**Reference: 4386 Rideau Valley Road – Response to Third Review Comments
Draft Plan and Zoning By-law Amendment Applications
City Files: D02-02-22-0118 & D07-16-22-0026
Our File: 121153**

Novatech has filed Draft Plan and Zoning By-law Amendment applications to allow the development of the above site. This letter responds to comments on the third submission received February 26, 2025. Responses are provided below each of the comments in bold text. For brevity, we have removed comments that have been resolved. The responses should be read together with resubmission package provided separately.

LOCATION CITY OF OTTAWA STINSON LANDS SUBDIVISION	PROJECT No. 121153-00
DRAWING NAME CONCEPTUAL GRADING, EROSION, & SEDIMENT CONTROL PLAN	REV # 1
	DRAWING No. 121153-GR2

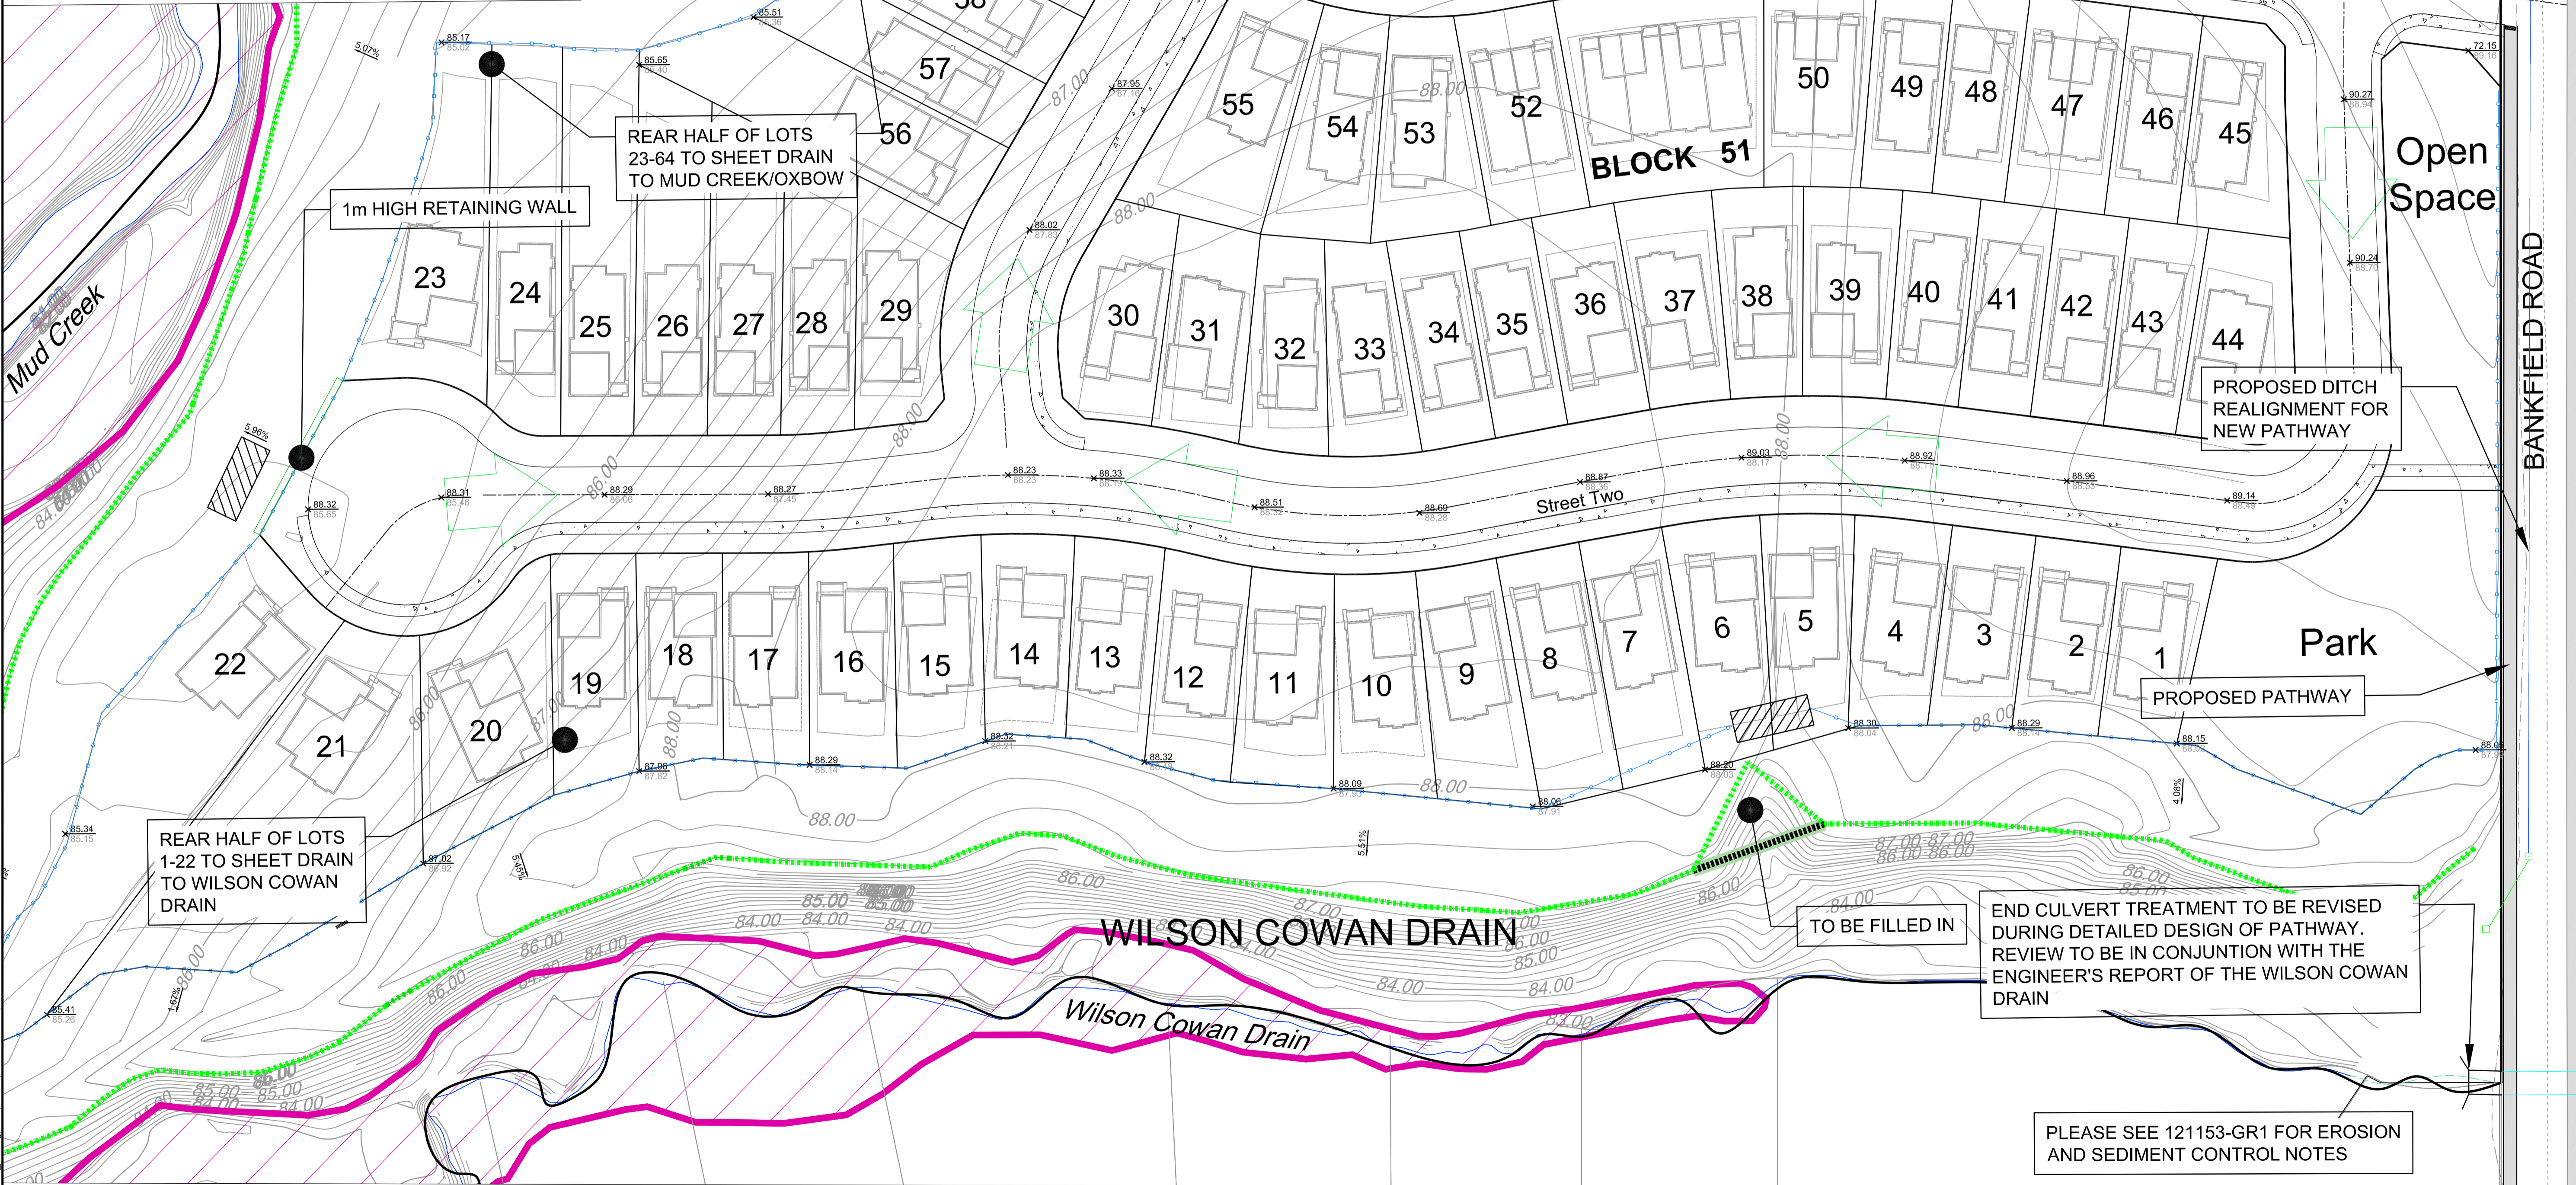
4. Conceptual Grading, Erosion, & Sediment Control Plan, drawings 121153-GR1 and 121153-GR2, submitted within Site Servicing and Stormwater Management Report

- a. Differentiate between drawings titles, ie. "Conceptual Grading, Erosion, & Sediment Control Plan 1" and "Conceptual Grading, Erosion, & Sediment Control Plan 2".

- b. Revise plan to correspond with revised Draft Plan of Subdivision including but not limited to road dimensions, Lot and Block configuration, and Lot and Block numbering.

- c. Plan should clearly show and state that proposed servicing outside of lands subject to the Draft Plan is conceptual and not subject to formal review and approval as part of this application.

- d. Submit drawings separately, in addition to including in the Site Servicing and Stormwater Management Report.

Response: Plans revised.

Response: Plans revised.

Response: Hatch shown to depict phase limits.

Response: Drawings separated as requested.
